Development Facilitation Team (DFT) – Review Comments

DRB Project No: PR-2023-008157 Date: 9/27/2023 Agenda Item: 2 Zone Atlas Page: J-13

Location: 1810 Bellamah Ave NW between 18th ST NW AND 20th ST NW

Application For: SD-2023-00175- PRELIMINARY/FINAL PLAT (DHO)

EXHIBIT A – EXISTING RETENTION POND LOCATED AT THE EASTERN EDGE OF LOT 1-B, FREEWAY-OLD TOWN, LIMITED

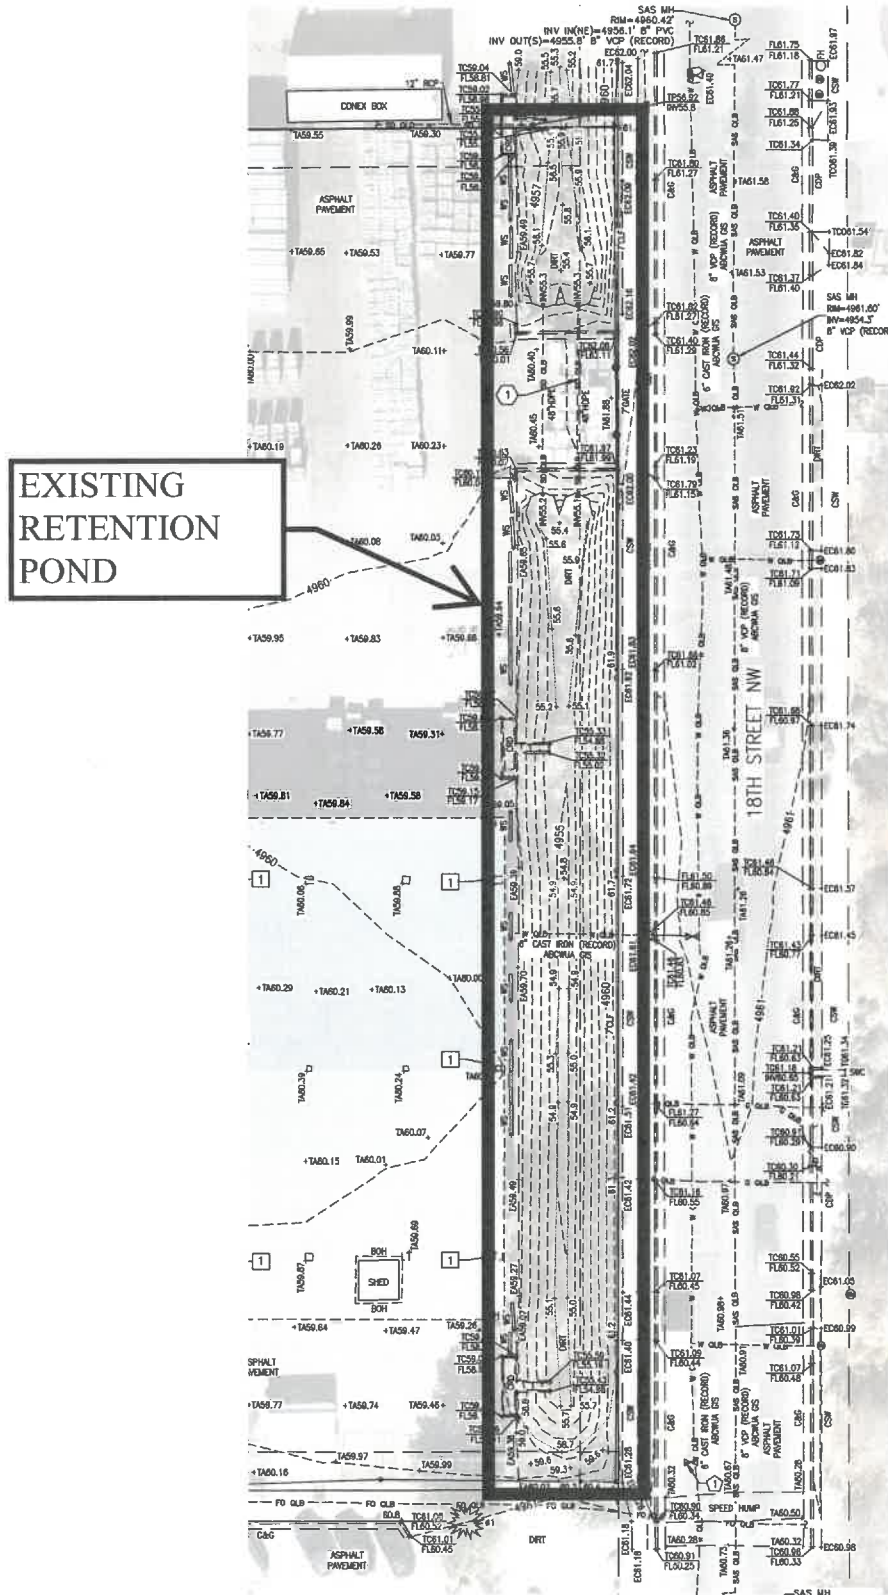
- Hydrology has an approved Conceptual Grading & Drainage Plan (J13D218) with engineer's stamp 05/12/2023.
- Please place the existing retention pond in a Private Drainage Easement with the Easement notes.

PLAT OF  
**LOTS 1-B-1 AND 1-B-2**  
**FREWAY-OLDTOWN, LIMITED**  
ALBUQUERQUE, BERNALILLO COUNTY, NEW MEXICO  
AUGUST, 2023

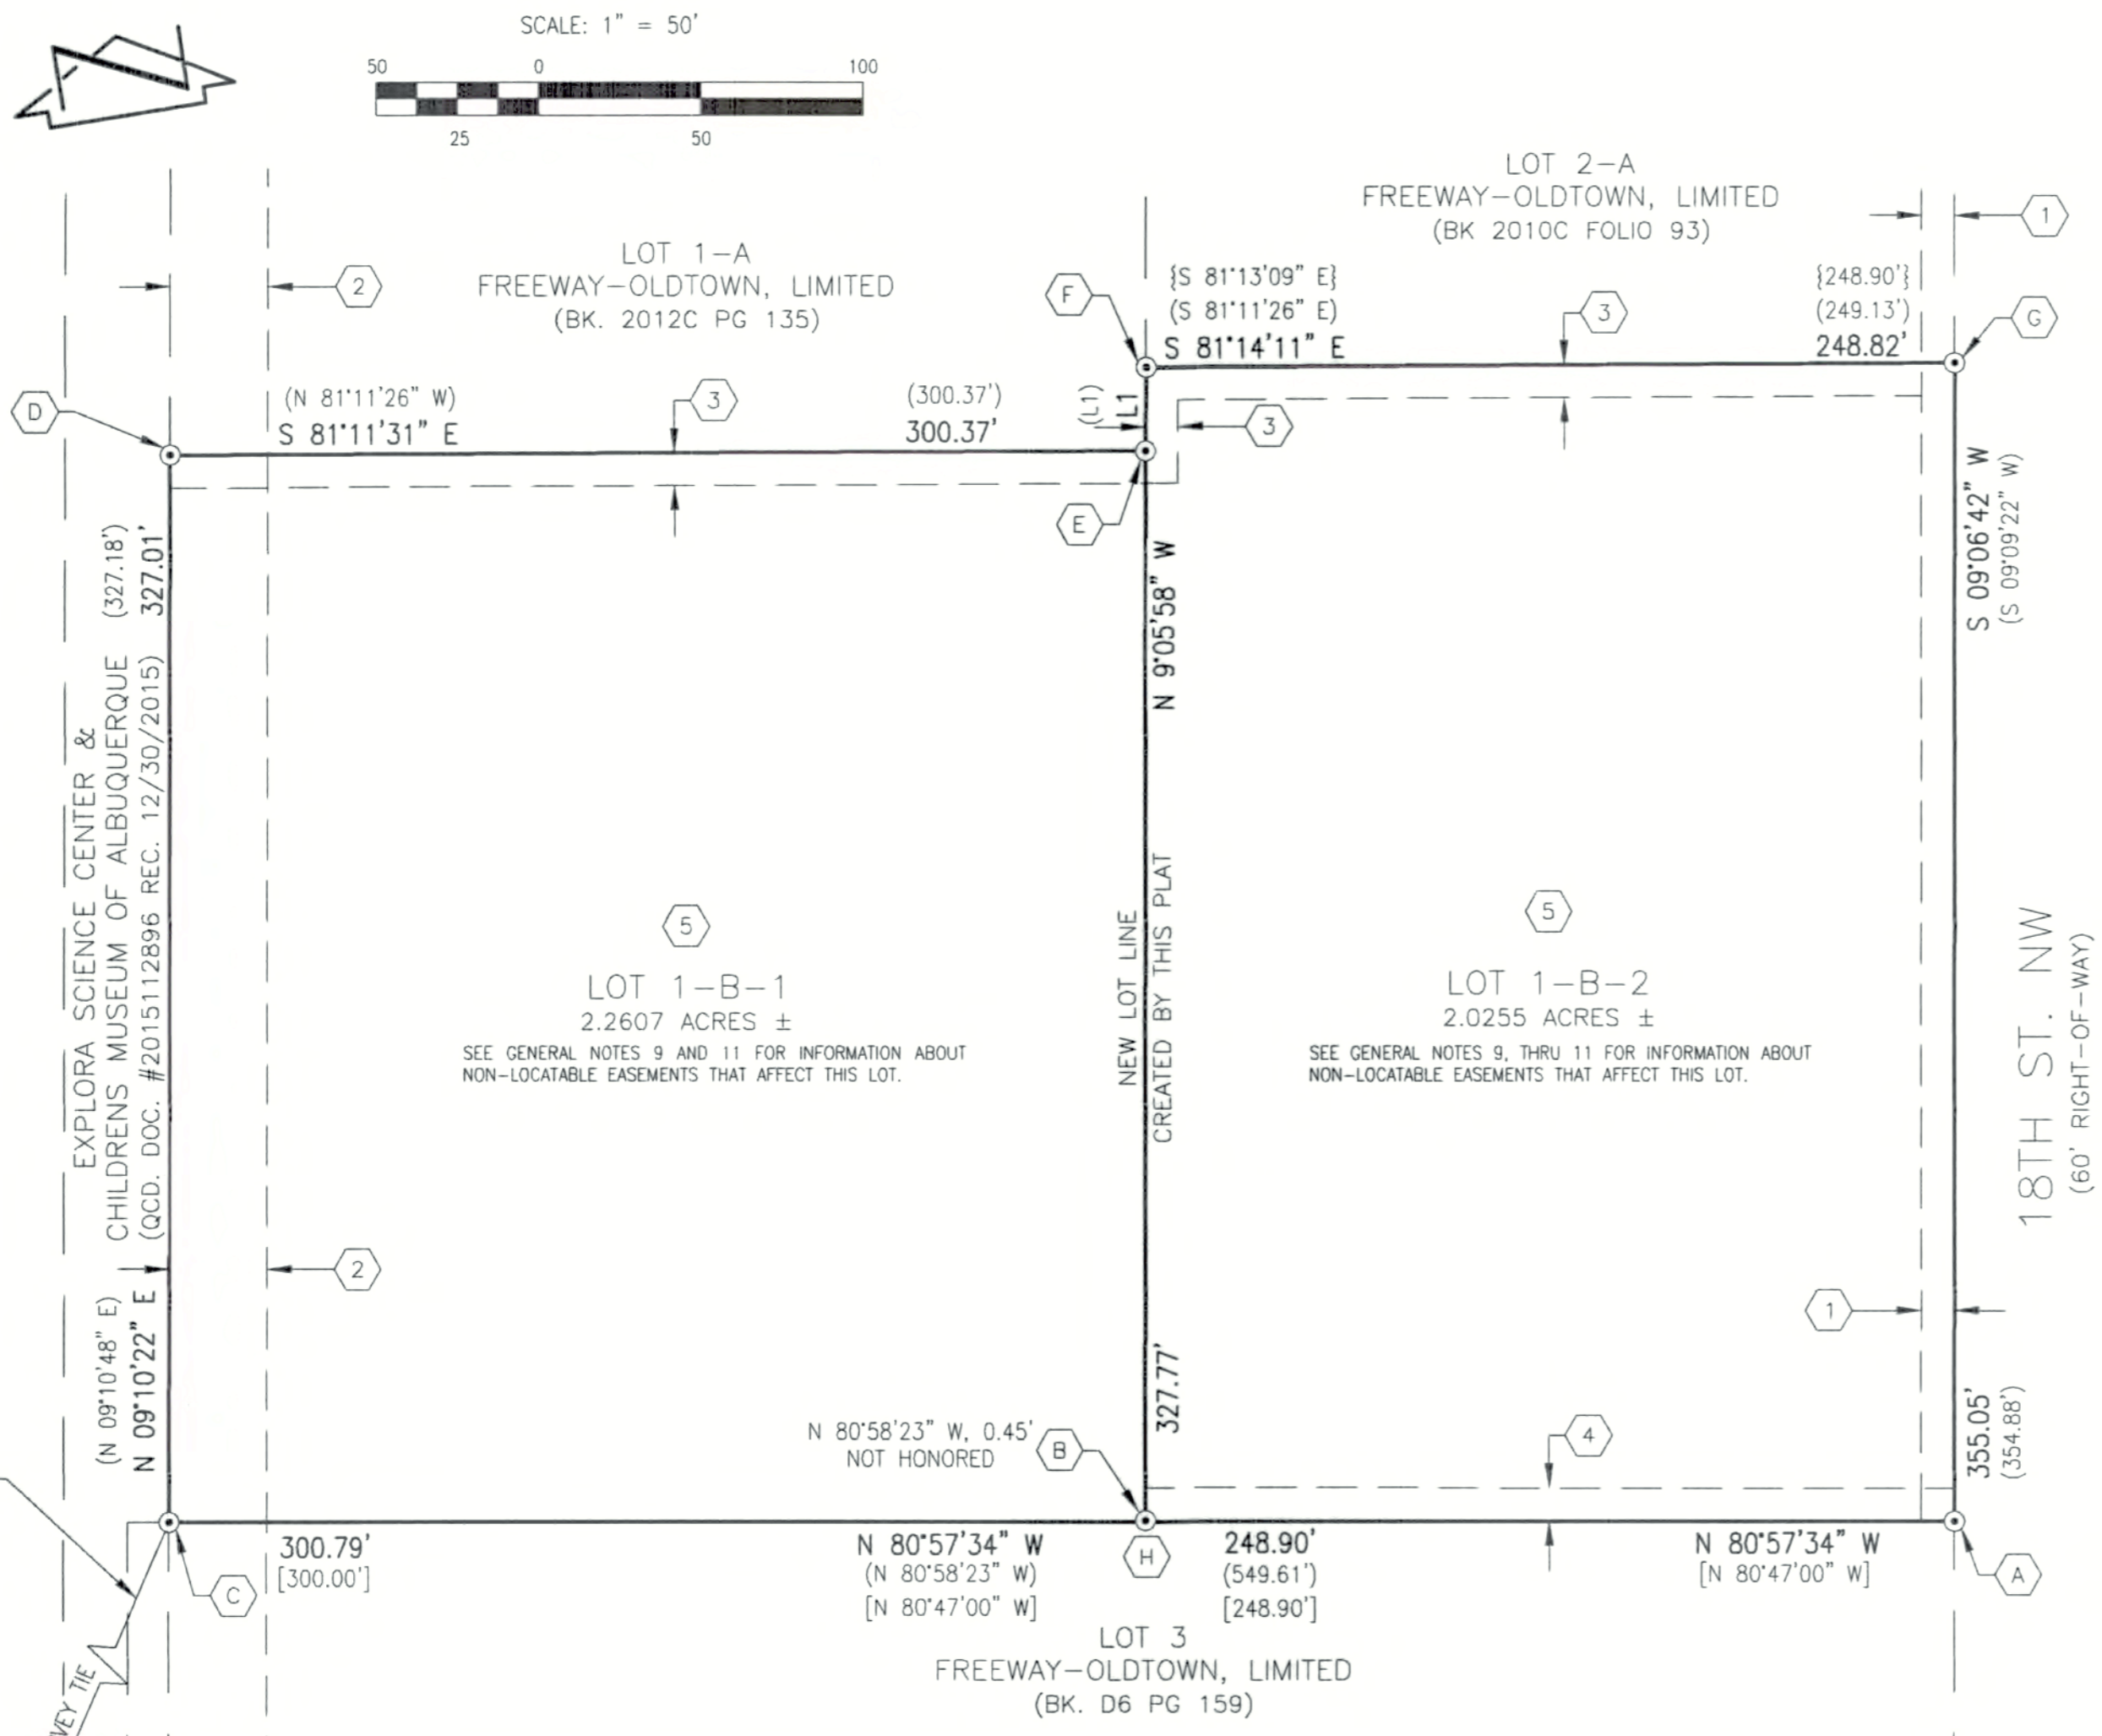
6. Easements:
 - a. Add the following note on the plat when easements are being granted for public water and/or public sanitary sewer infrastructure:

- b. Include all public water and/or sanitary sewer easements on the plat, including those that are adjacent to the subject property’s boundaries. Surveyor shall field verify the location of existing public water and/or sanitary sewer infrastructure to determine if existing public water and/or sanitary sewer easements are sufficient. If the easement(s) does not exist, a new easement shall be granted. The width of the easement shall be the standard width, unless specified by the Water Authority.
- c. Exclusive public water and sanitary sewer easements are required for all public lines that are to be constructed outside of any dedicated rights-of-way. A minimum width easement of 20’ is required for

7. Please remove any storage that is currently being placed over the line.
- a. This can cause issues when maintenance or repair needs to take place of the existing line. Especially in a situation of a collapse, the easement must remain clear for access, operation, and maintenance for the public sanitary sewer line.
